6 No. one bed apartments. This application affects the character & appearance of the Rustington Conservation Area.

Land Adjacent Abbots Lodge 85 The Street Rustington

Thank you for your internet comments made on 27th July 2017 which has been recorded as **'an objection'** with the comments as follows:

SITE PLAN SCALE 1:200 @ A3

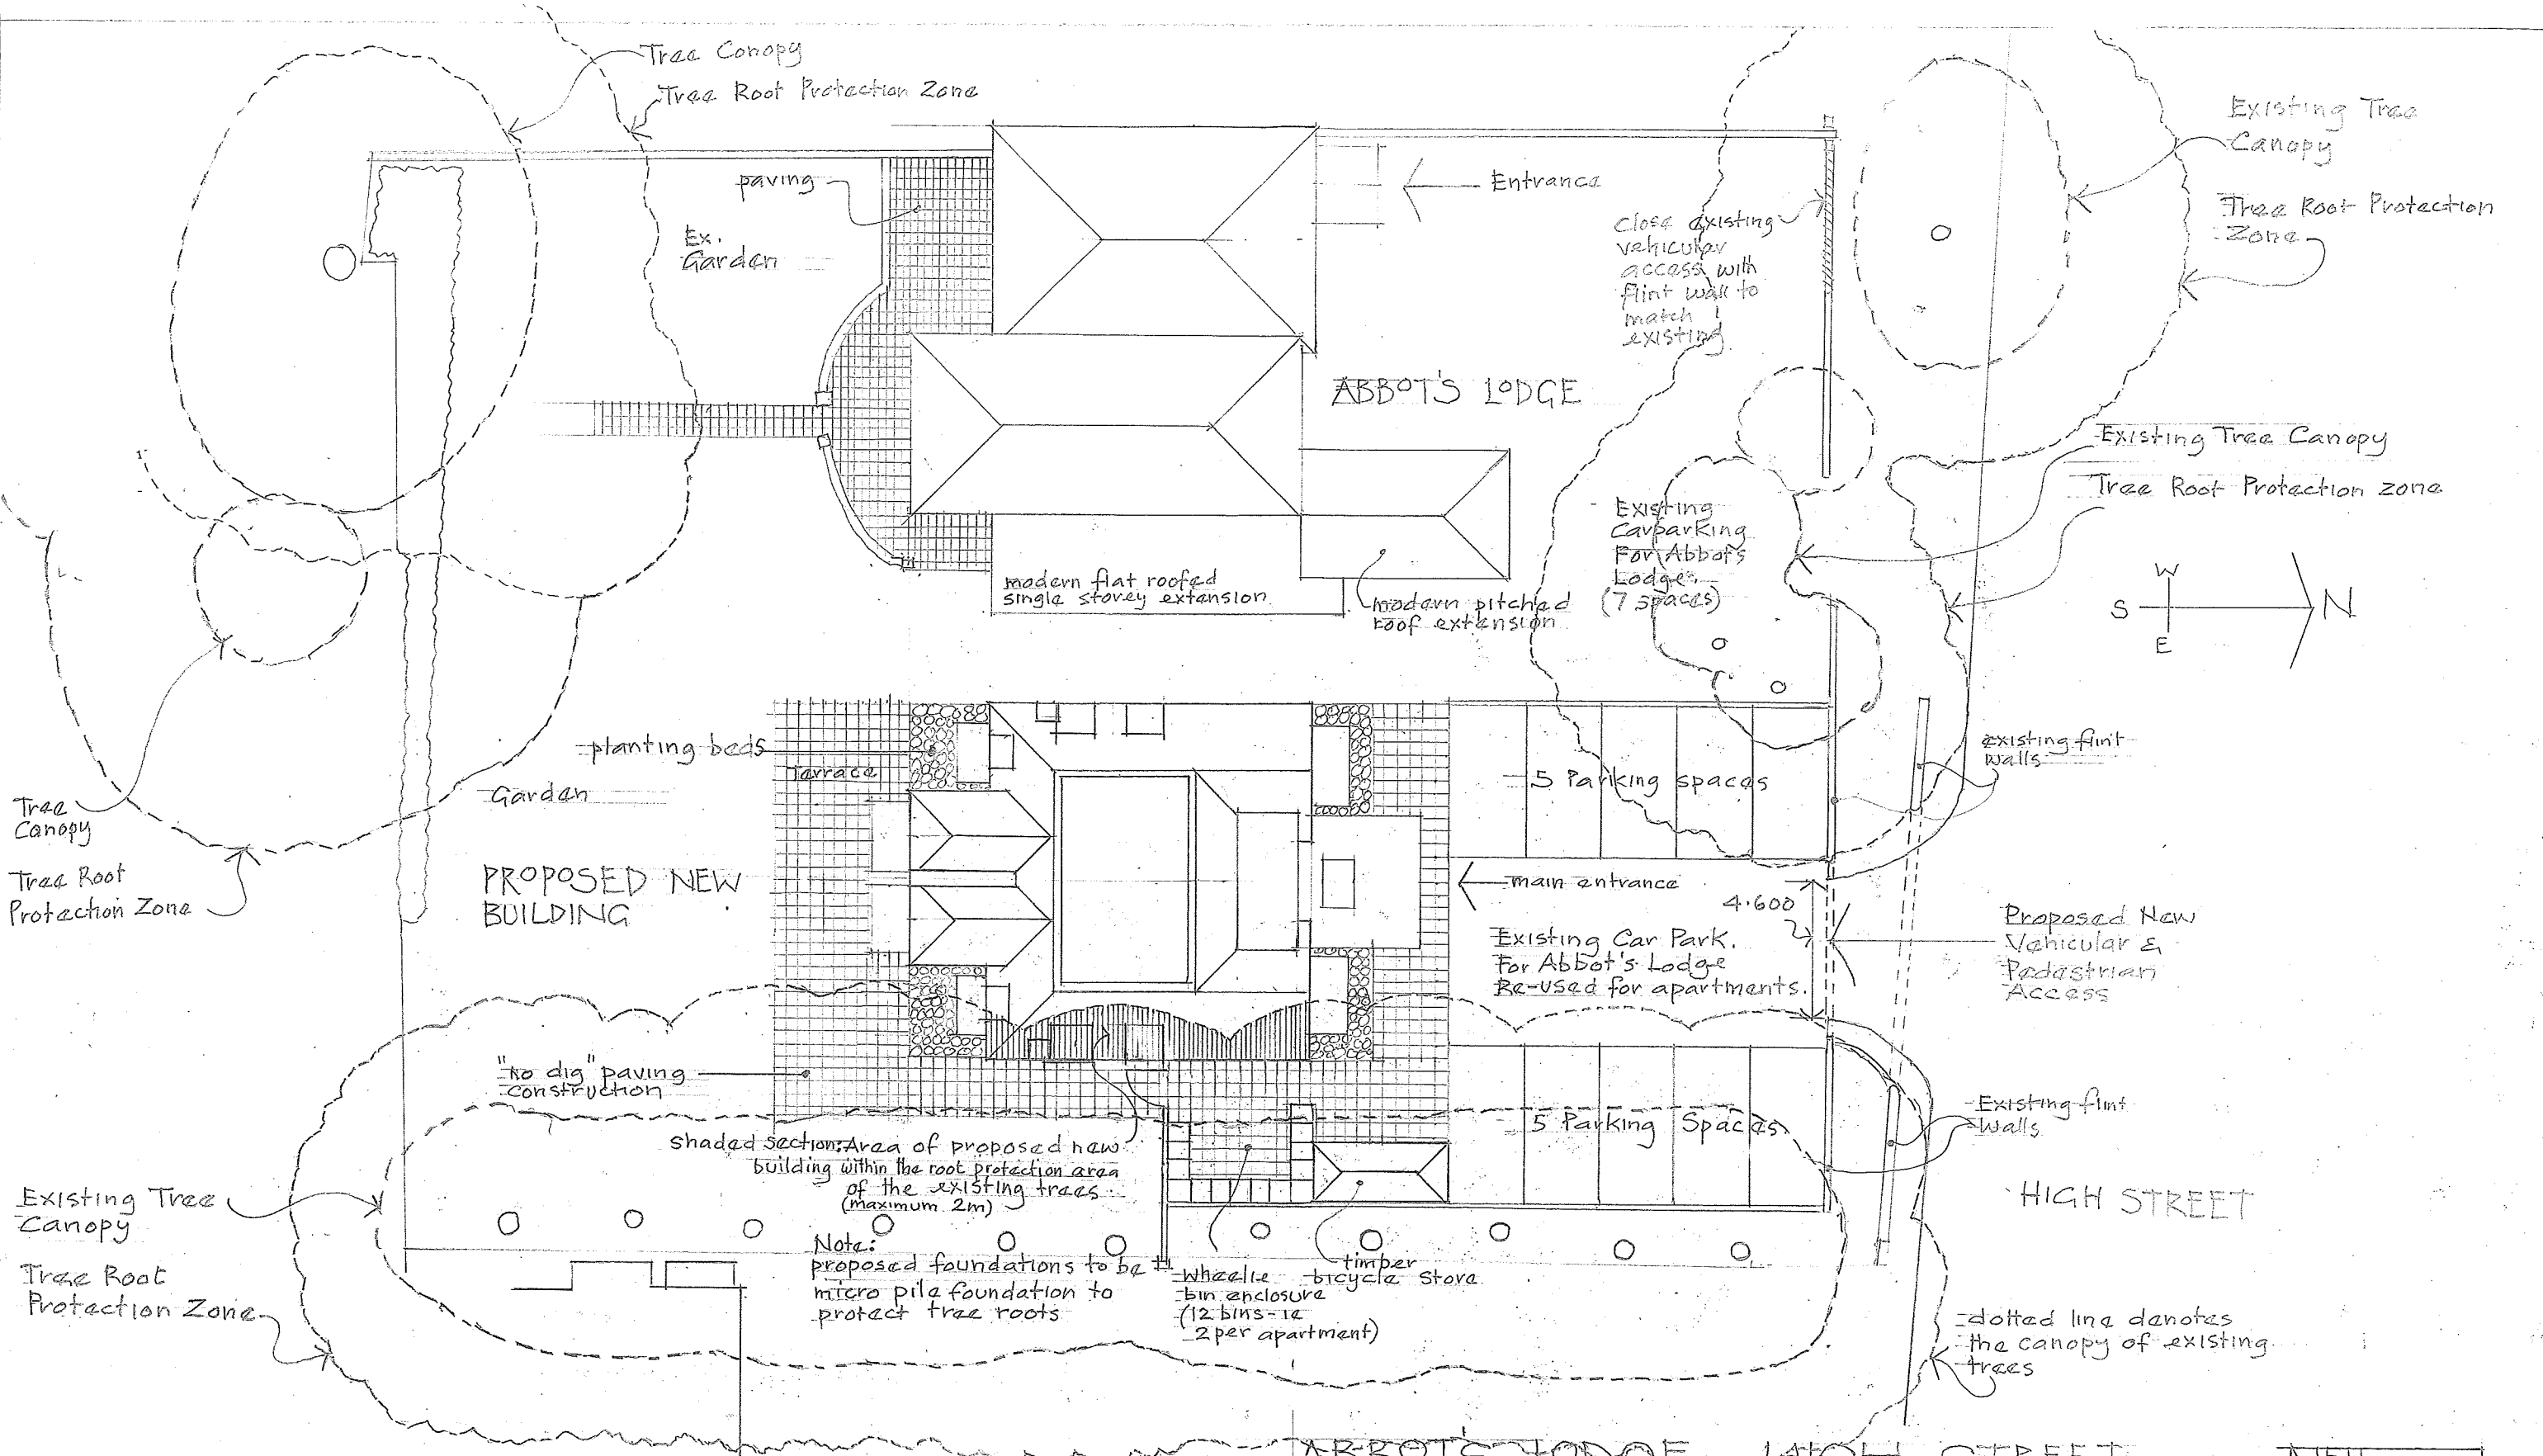
(e) The proposal would give rise to an increased movement of vehicles on to and off the highway at this point, which would be detrimental to the safety and free-flow of traffic, and would add to the risks for highway users to an unacceptable degree

NORTH ELEVATION [Proposed Apartments]

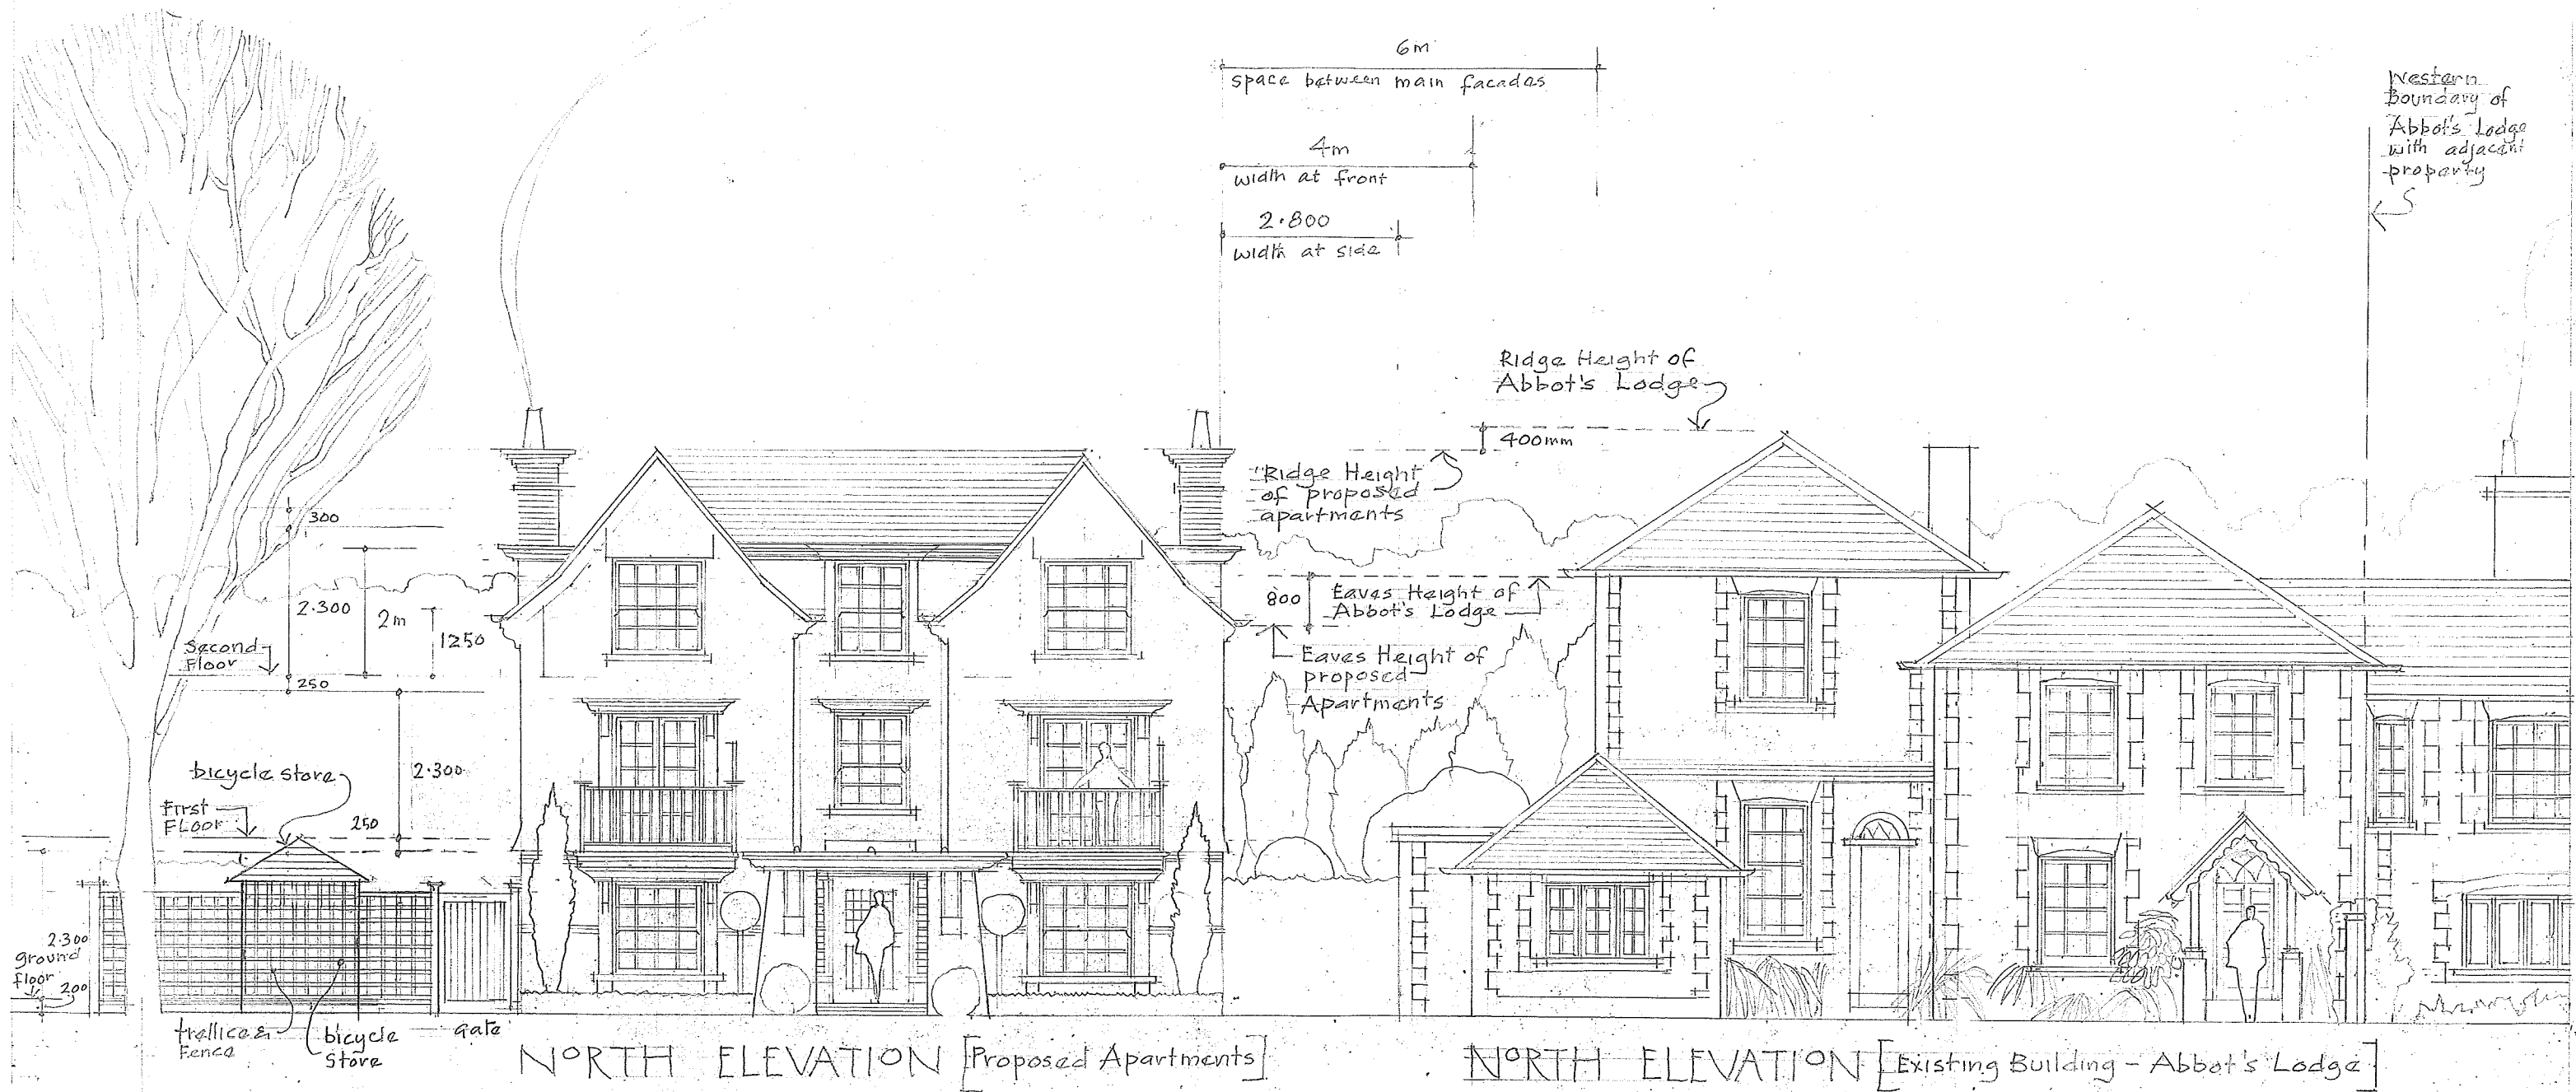
(b) The proposal, by reason of its height and mass, would be detrimental to the visual amenities of neighbouring property and would most certainly represent and over-development of the site. The size and shape of the plot would also not permit development of a standard compatible with the existing development in the area

(d) The proposed new dwellings would be out of keeping with the individual and unique character of the established buildings in The Street, and would most certainly have an adverse effect on the street scene and, in particular, the front fa ade
